Application No: FG/155/25/PL

Site Address: Land between 11A The Grove and 30 Brook Lane Ferring BN12 5HZ

Description of works: Erection of 1 No 1-bedroom self build house with associated parking & private outdoor amenity space. This application is in CIL Zone 4 and is CIL Liable as a new dwelling.

Thank you for your internet representation made on 30th January 2026 which has been recorded as an objection with the comments as follows:

A :: Proposed Ground Floor Plan
01 scale: 1:200

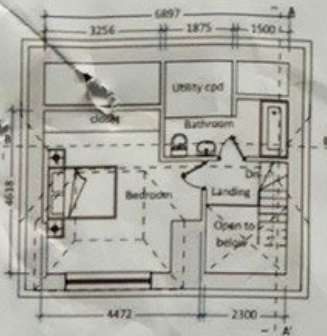
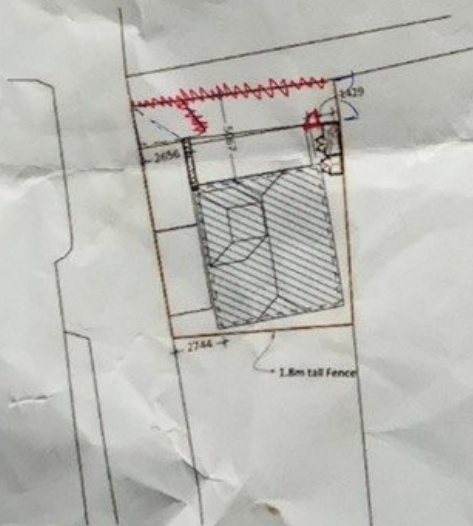
The property has a front ground floor and front first floor windows, this would lead to a significant reduction in privacy at our property.

A :: 2.4 x 4.8 Car Parking
01 scale: 1:200

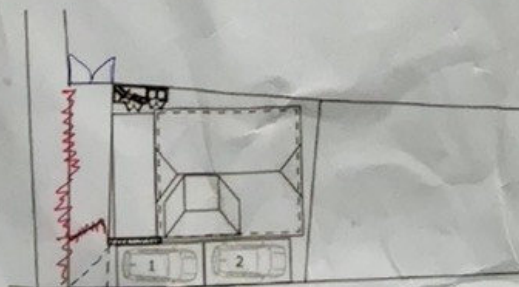
The planning provides for 2 car parking spaces, but the WSCC consultation details these are smaller than the recommended sizes., if the occupier does not own a small car, it is likely the car will protrude onto the road. This part of The Grove is very narrow and could have potential issues for the emergency services, refuse collection and residents of The Grove trying to enter or leave the Grove.
